Medworth Energy from Waste Combined Heat and Power Facility

PINS ref. EN010110
Document Reference: Vol 9.20
Revision: 3.0
Deadline 3
April 2023

Schedule of Changes (Deadline 3)

March 2023

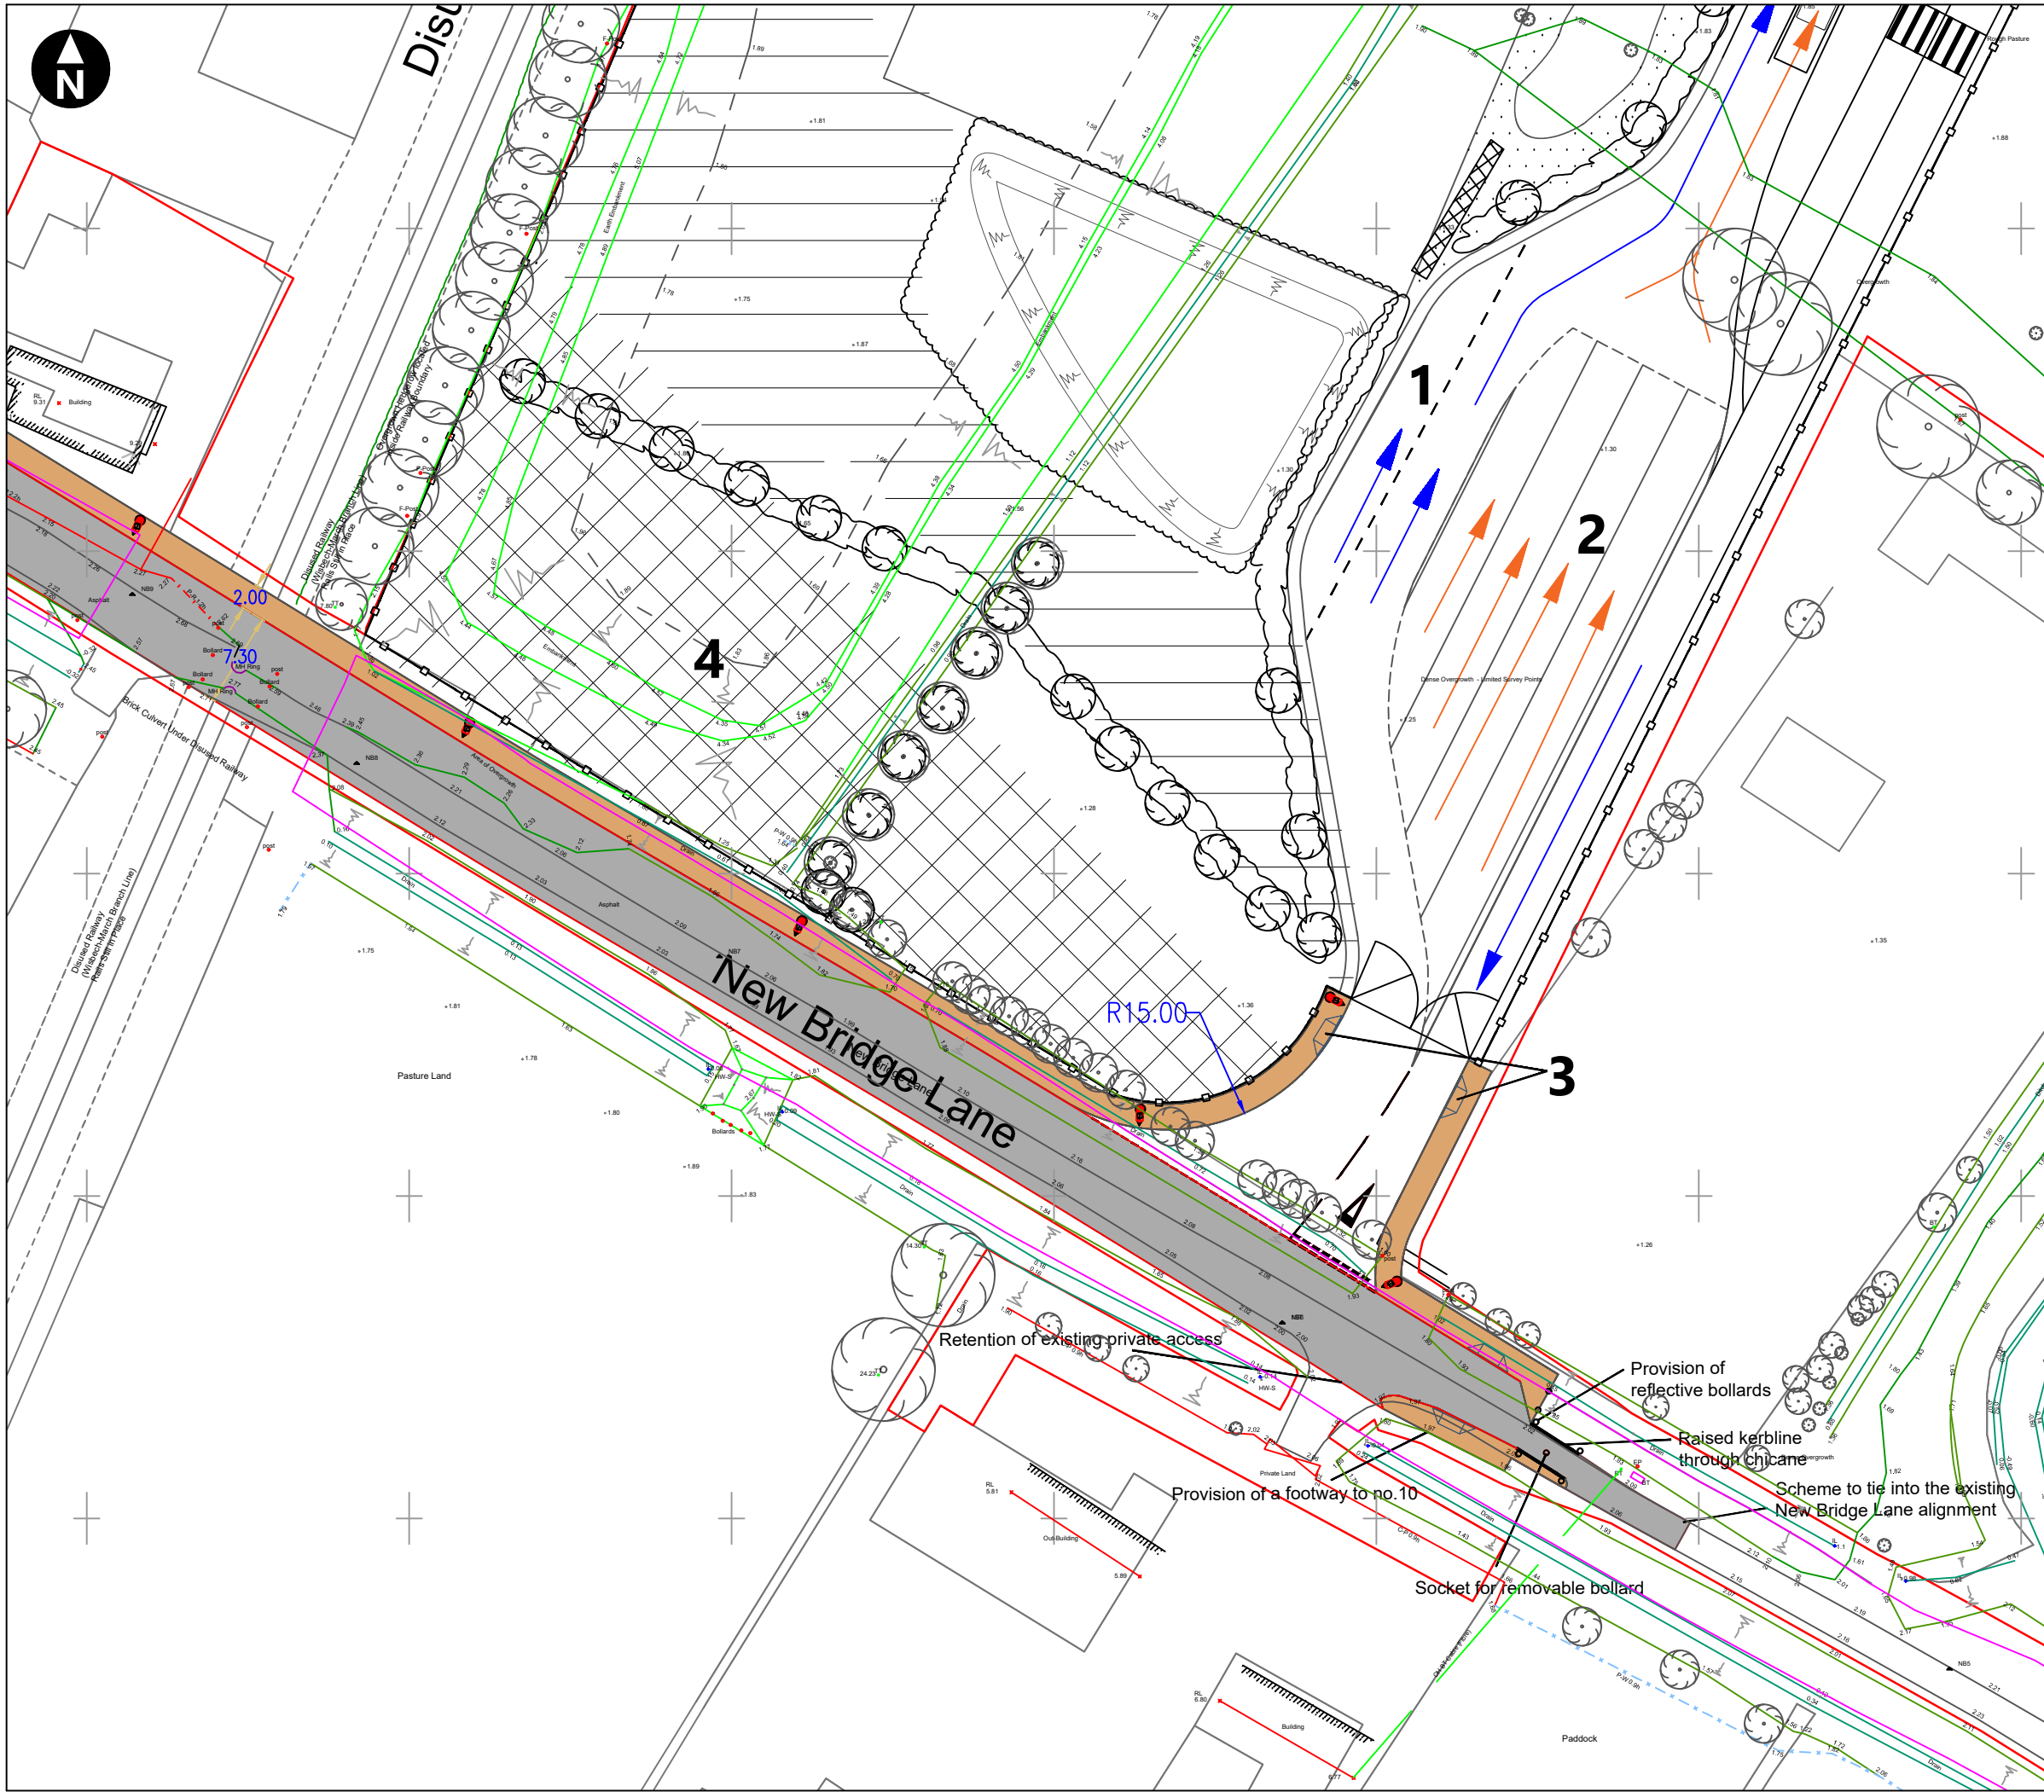
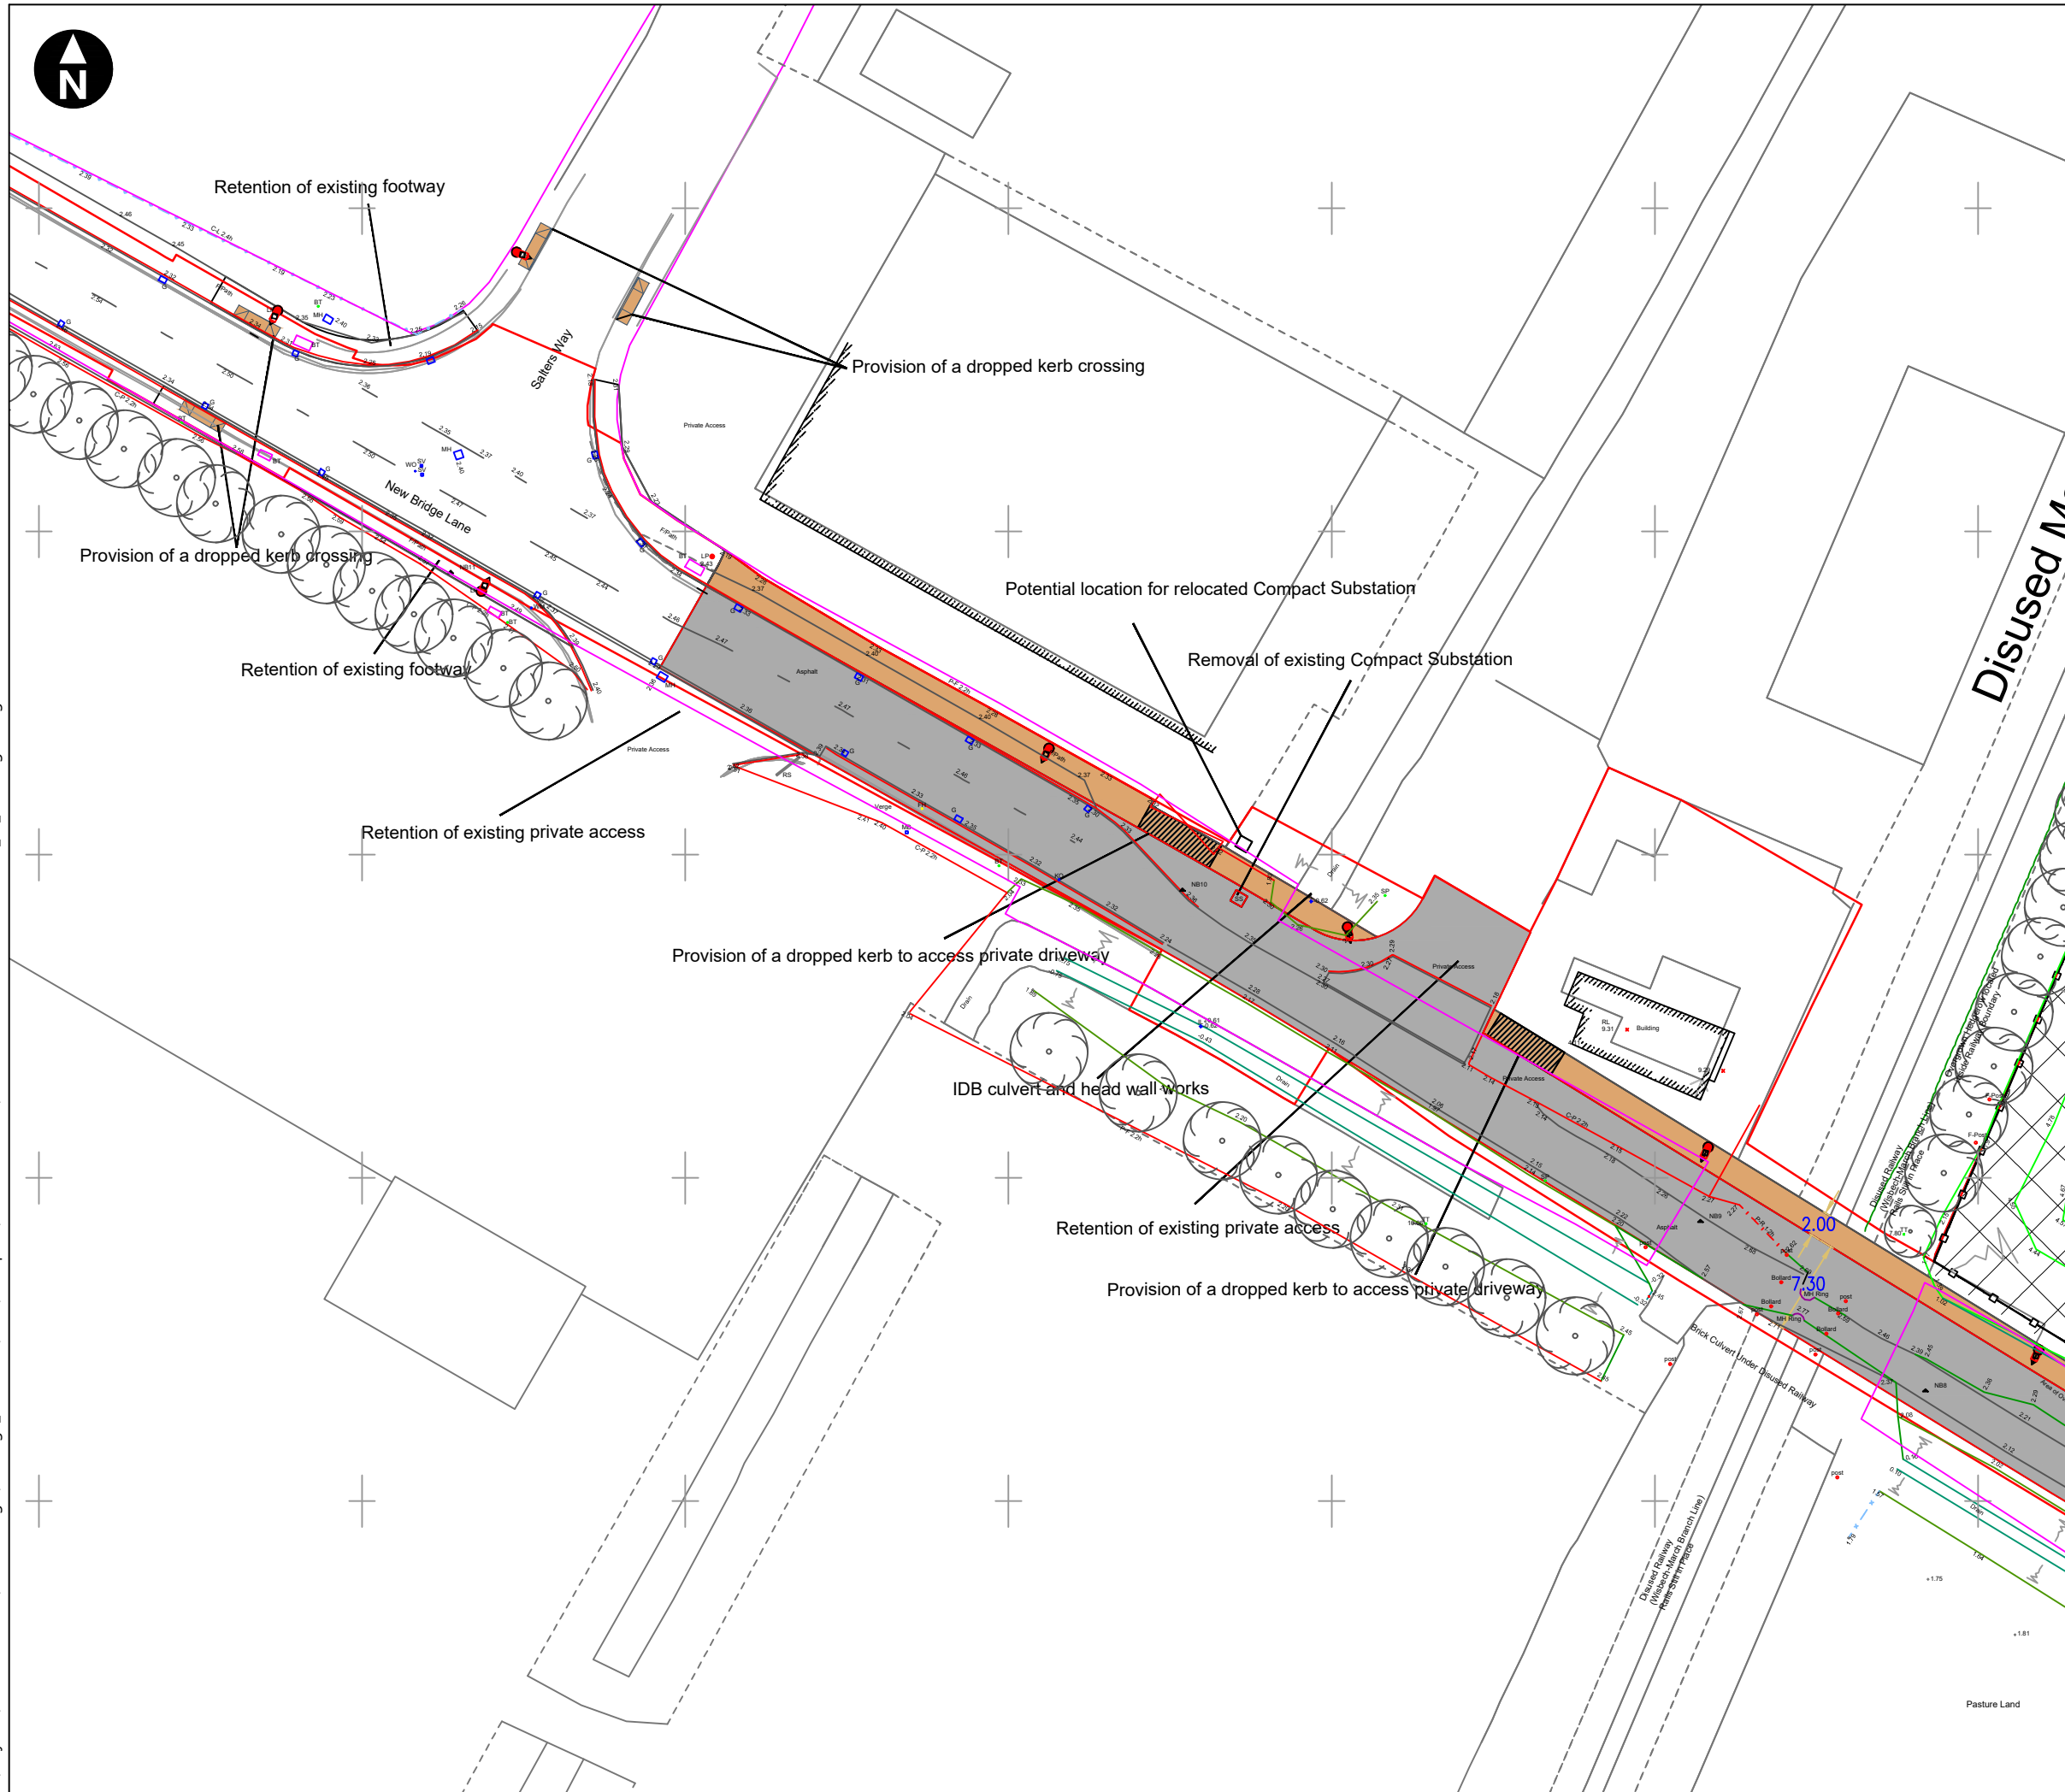
Document Updated	Change	Reason for change	Deadline submitted	Relevant Document version
Volume 6.4 ES Chapter 6 Traffic and Transport Appendix 6A Outline (CTMP) [REP1-011]	Paragraph 7.4.8 – additional paragraph to confirm that the Applicant, with the agreement of Network Rail, will retain/reposition/provide a sign setting out the rights of access applicable to NMUs at the point that New Bridge Lane crosses the Disused March to Wisbech Railway.	CCC and FDC LIR paragraph 2.4.3 [REP1-074] .	Deadline 3	Rev 3
Volume 6.4 ES Chapter 6 Traffic and Transport Appendix 6A Outline (CTMP) [REP1-011]	Additional drawings, Figures 9.2ii to show swept path of vehicle leaving New Bridge Lane. Also Figure 10.3i – ii to show outline design for construction accesses into the CHP Connection Corridor from Weasenham Lane and accompanying swept path.	CCC and FDC LIR paragraph 2.7.32 and 2.7.34 [REP1-074] .	Deadline 3	Rev 3
